**Re: Old Chevron Terminal at 3200 Broadway Blvd SE
Erosion and Sediment Control Plan
Engineer's Stamp Date 3/29/24 (C11E002)**

Based on the information in your submittal received on 4/4/24, the ESC plan cannot be approved until the following comments are addressed.

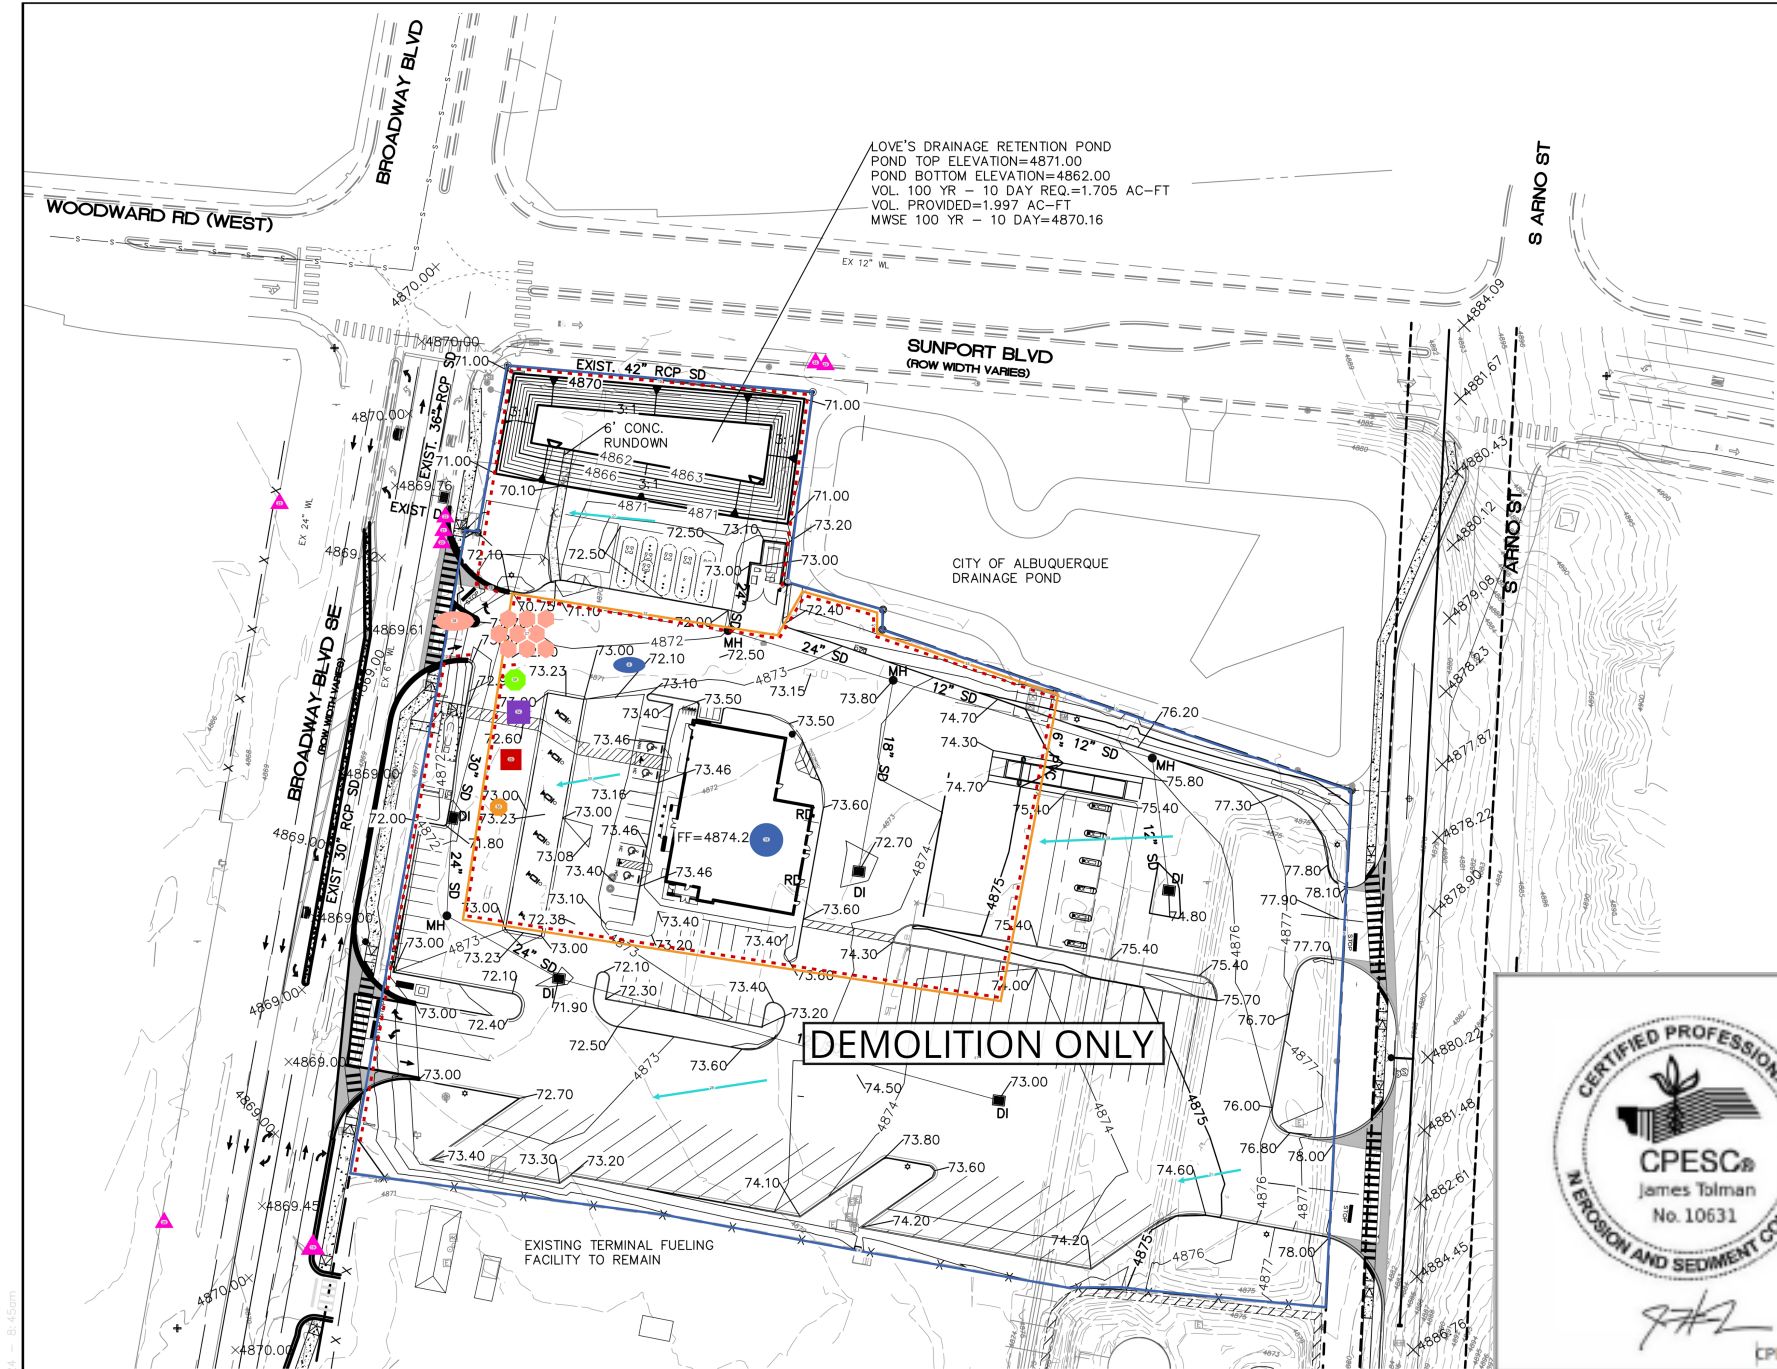
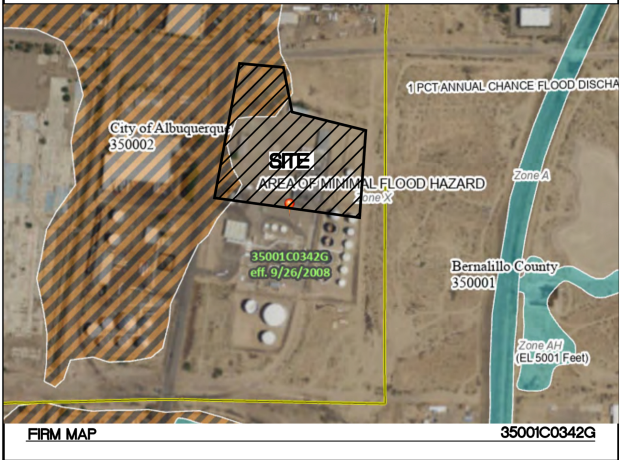
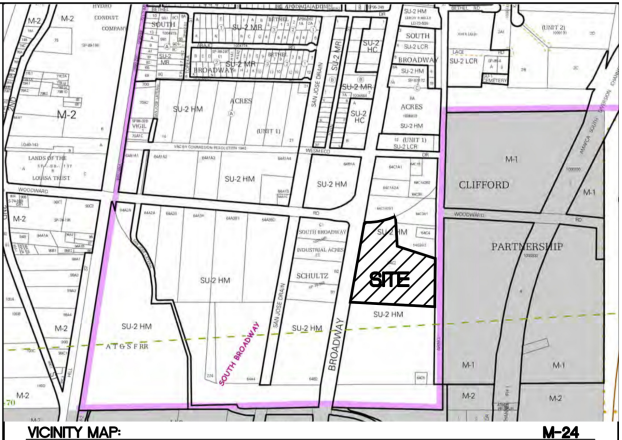
1. The ESC Plan can't be approved until after Hydrology approves the G&D Plan for each specific purpose, Site Plan, Grading, Building Permit, and Work Order. The only purpose Hydrology has approved so far is the Site Plan. The existing and proposed grades must be shown on the ESC Plan, and they must agree with the Grading Plan approved by Hydrology (CGP7.2.4.b.ii);

3. The ESC Plan shows buildings, sidewalks, and paving to be constructed outside of the limits of disturbance. Show only the construction and stabilization that will be completed under this NOI and include a schedule/sequence of construction.

5. Diversion berms are required around the low side of the site to divert drainage into the proposed retention pond, and the pond and berms must be the first items of construction (before any building demolition).
